OXFORDSHIRE COUNTY COUNCIL'S RESPONSE TO CONSULTATION ON THE FOLLOWING DEVELOPMENT PROPOSAL

Application no: 22/00913/REM

Proposal: Reserved matters application to 19/01746/OUT - layout, scale appearance and landscaping details for employment development (5,161sqm GIA), with associated landscaping and infrastructure works

Location: Land Adj To Promised Land Farm, Wendlebury Road, Chesterton

Drawing Title. **CYCLE SHELTER DETAILS**

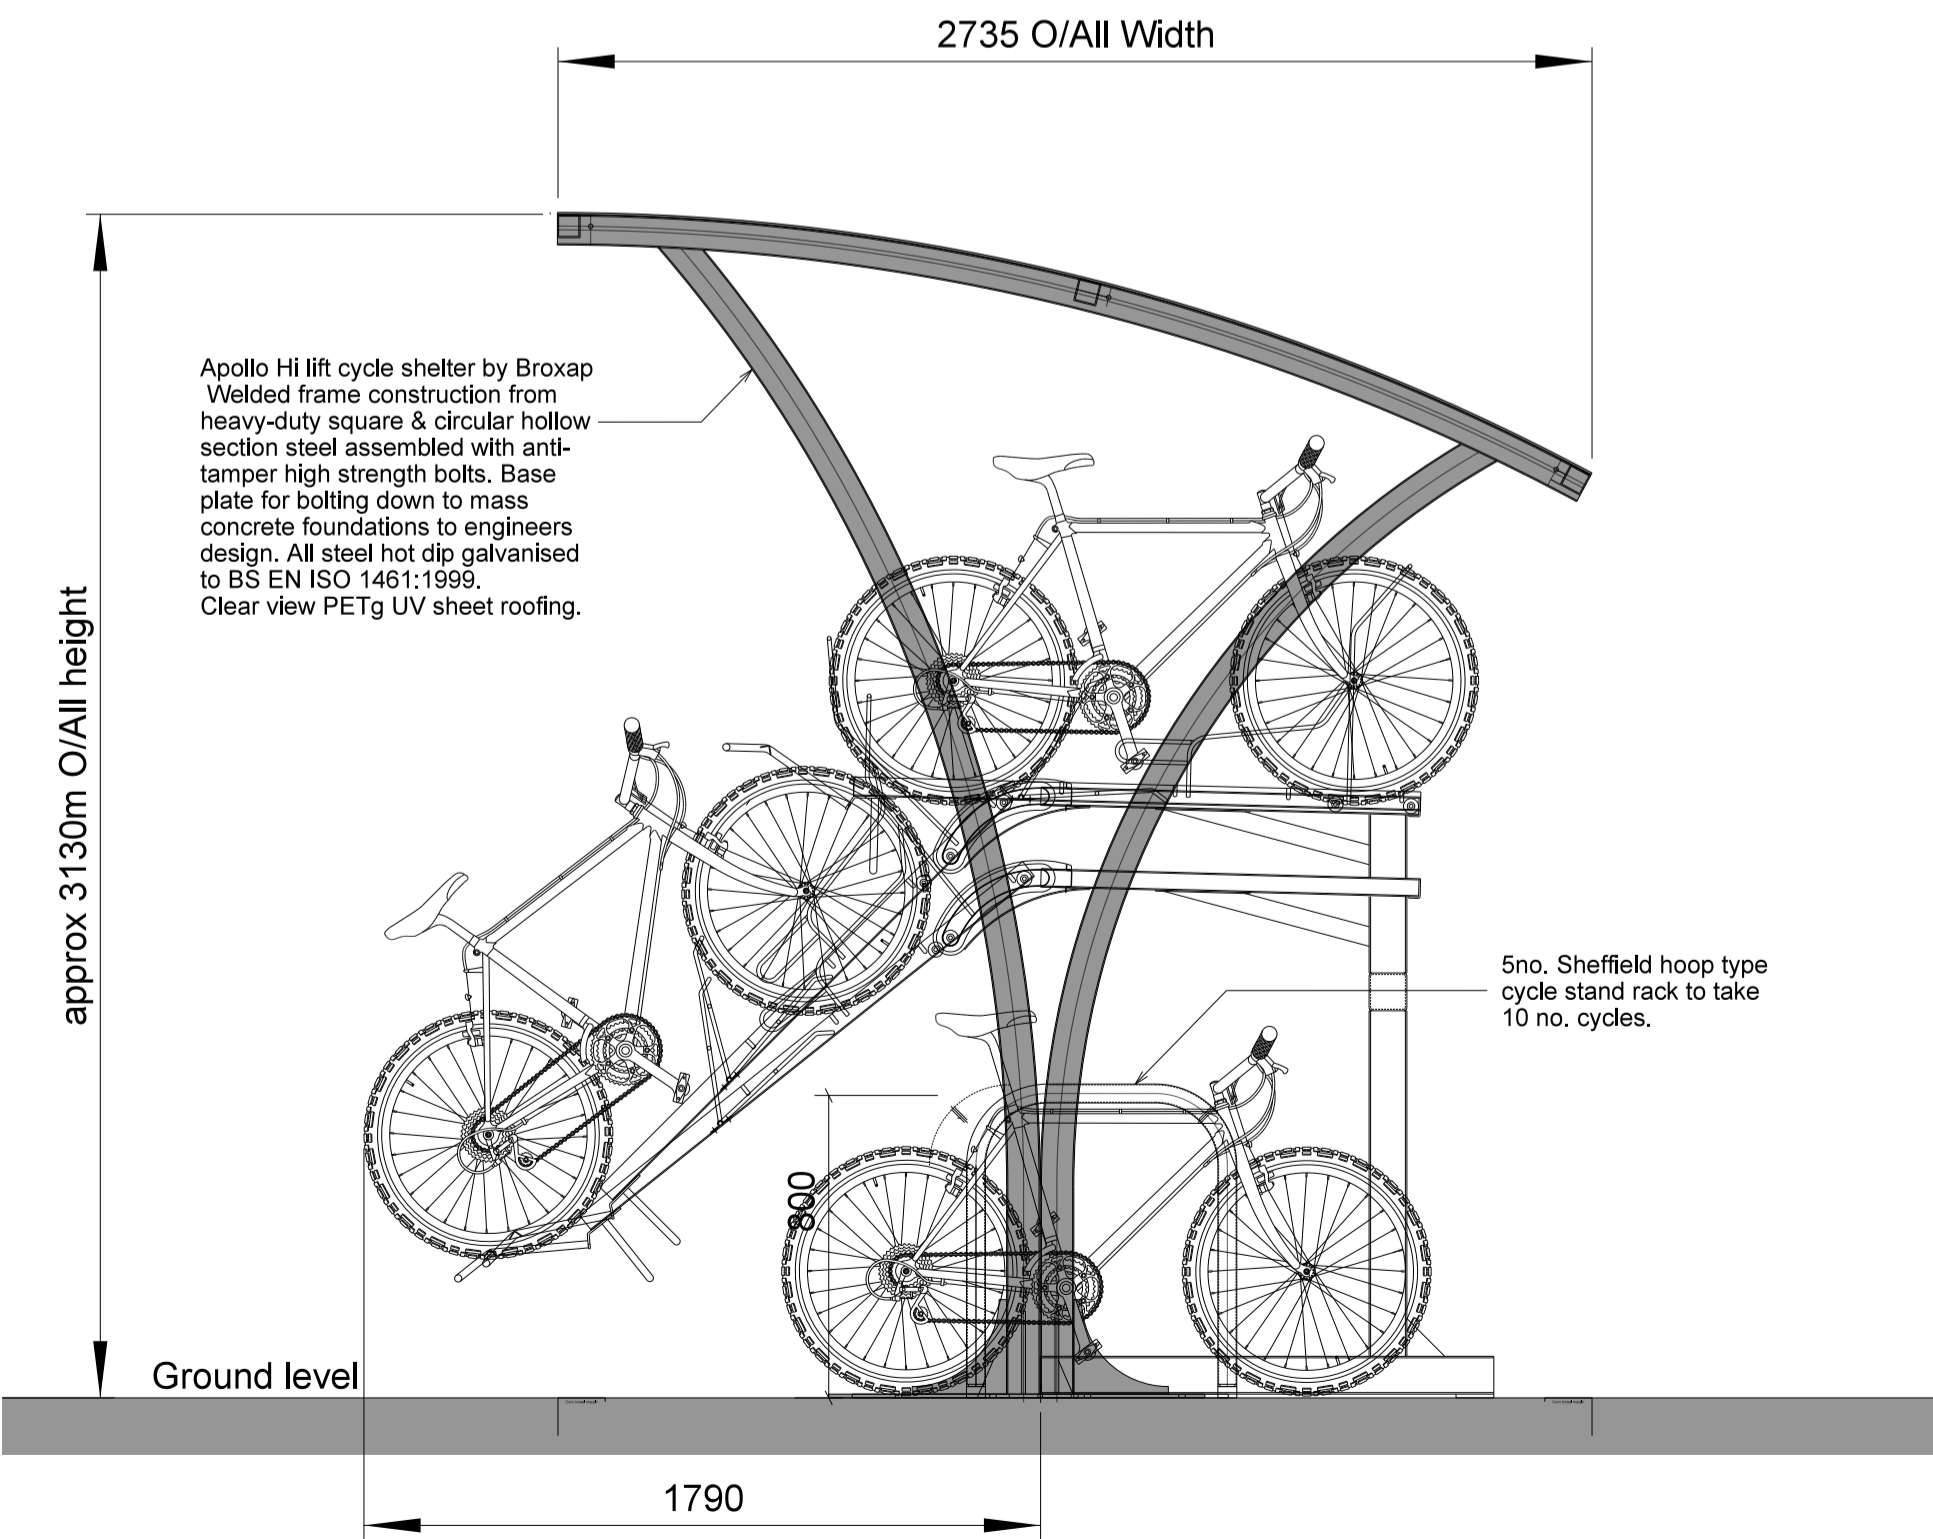
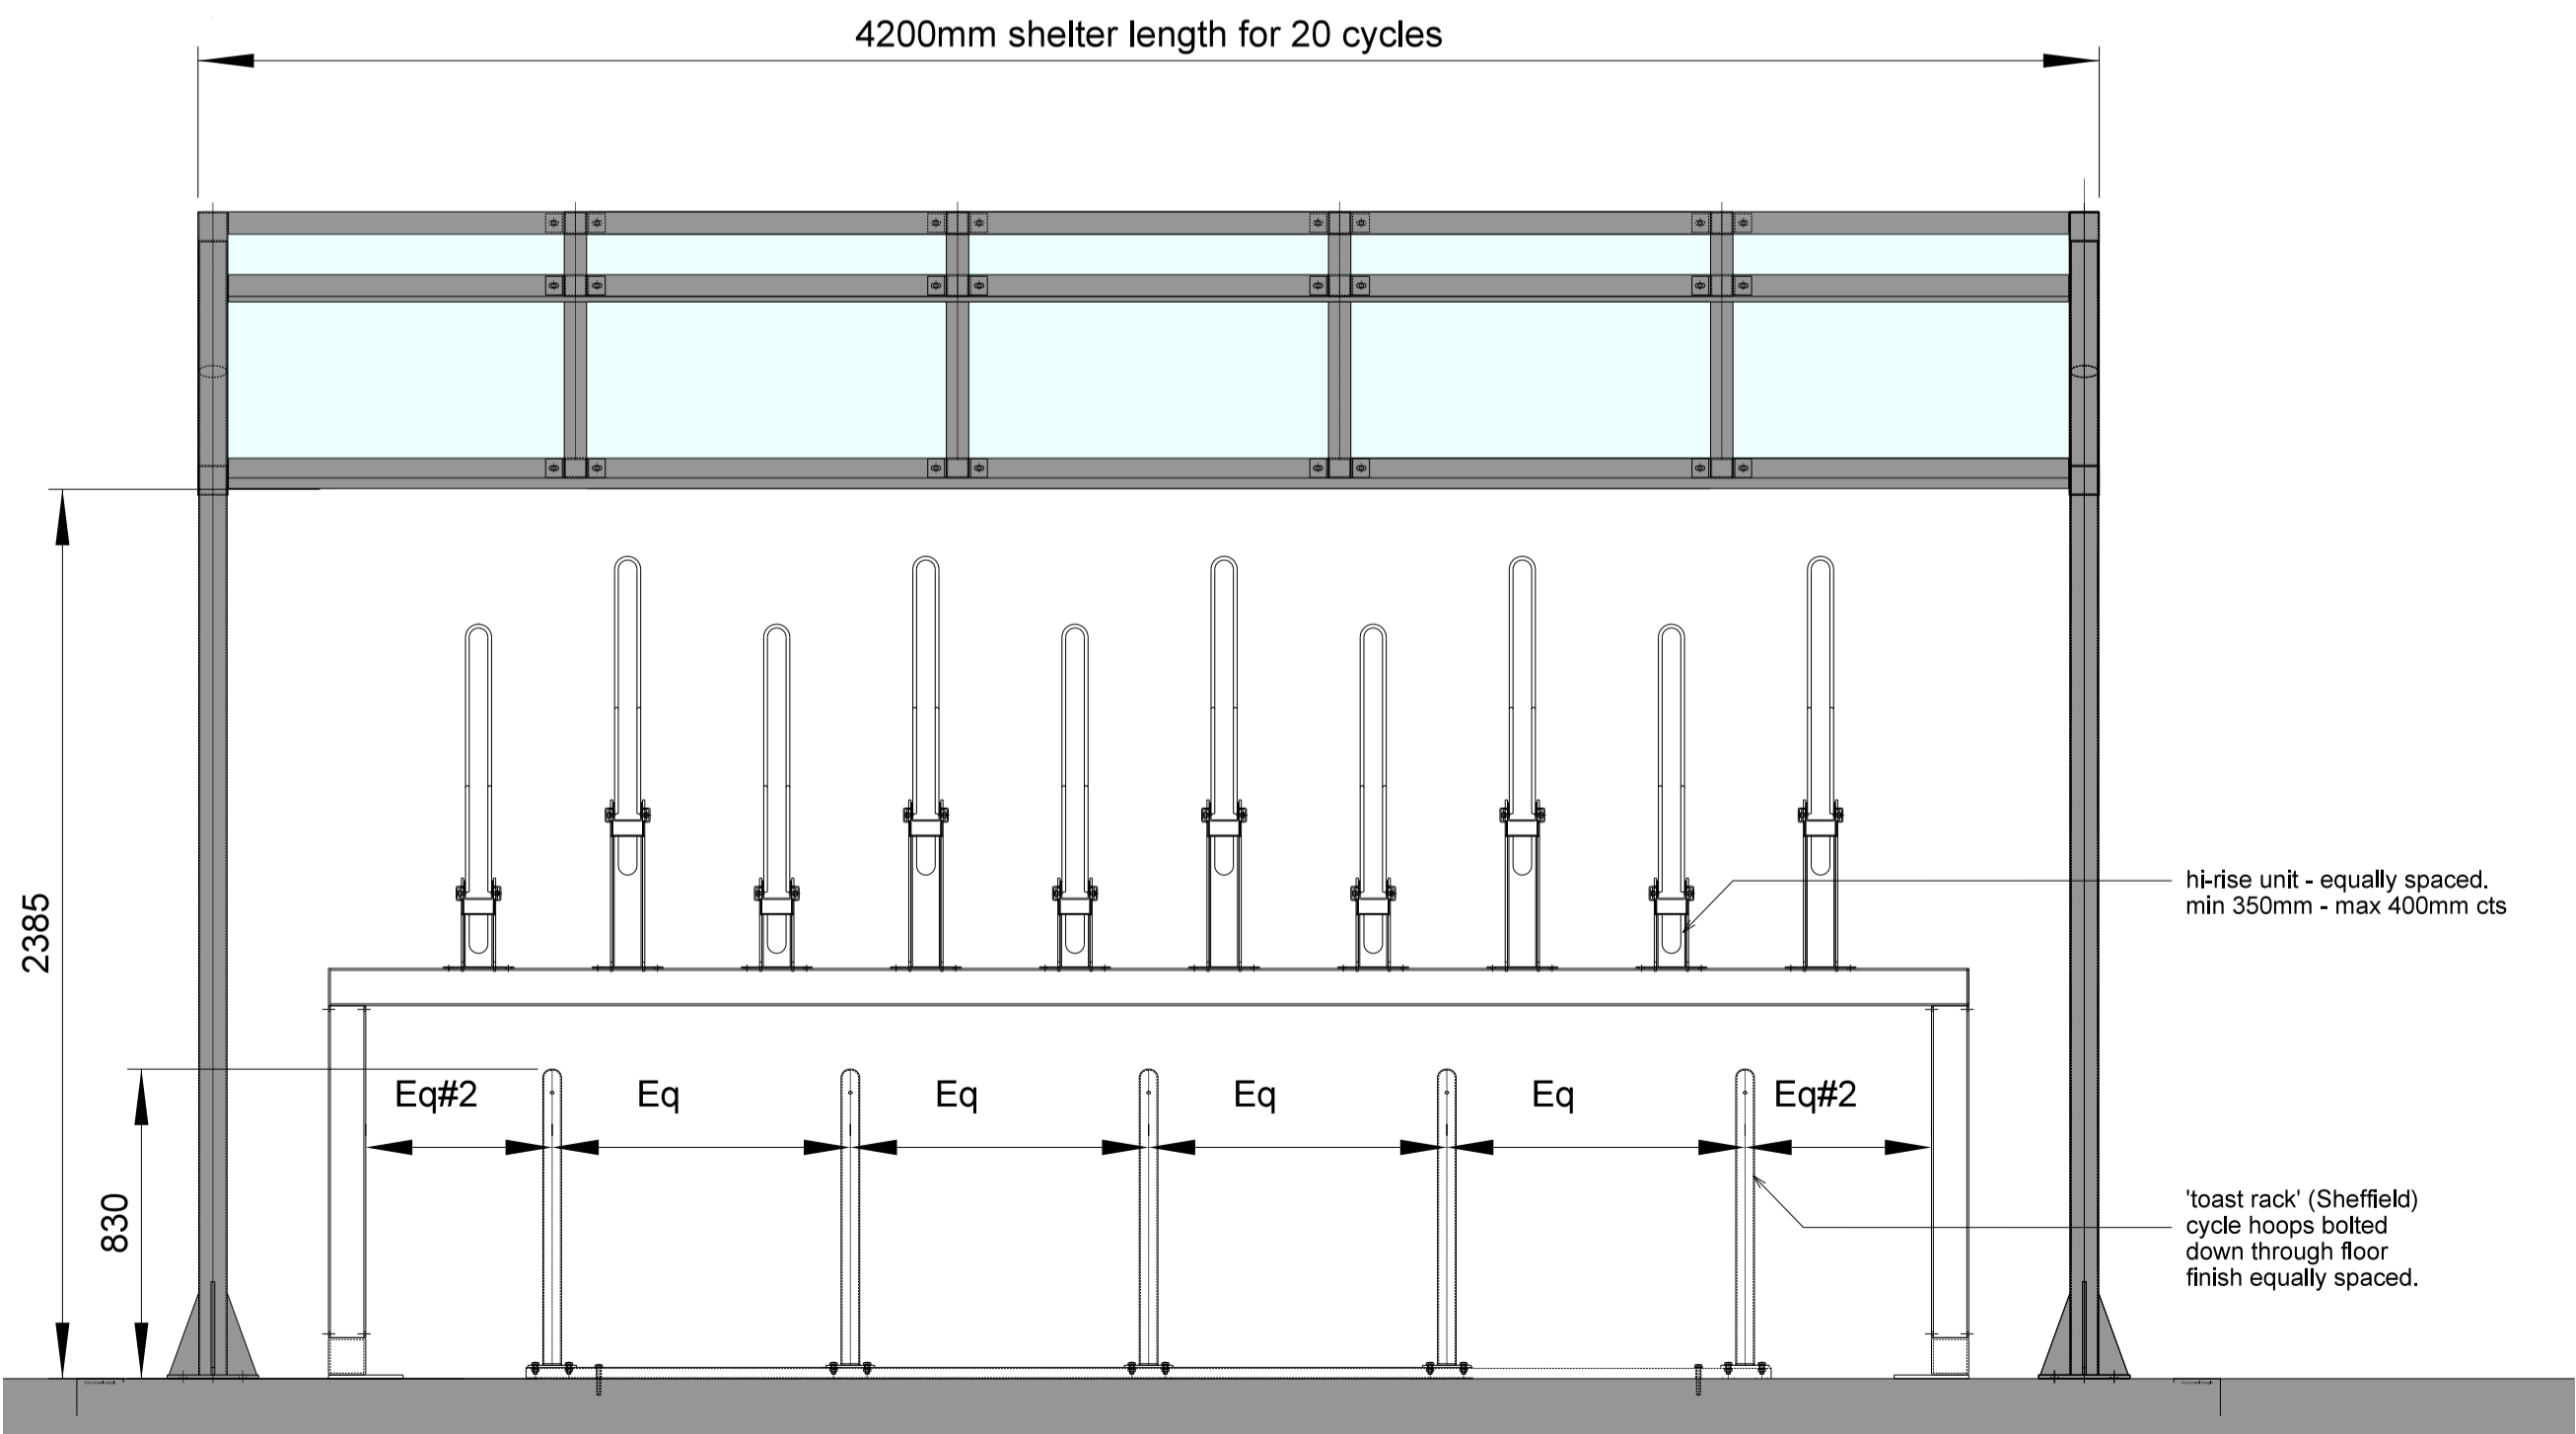
Cycle Parking - The amount of cycle spaces proposed (40) for a development of this scale is acceptable. That said, a separate bank of cycle parking is noted within the western car parking area and away from any buildings that they serve. This is not in line with encouraging use of the parking facilities.
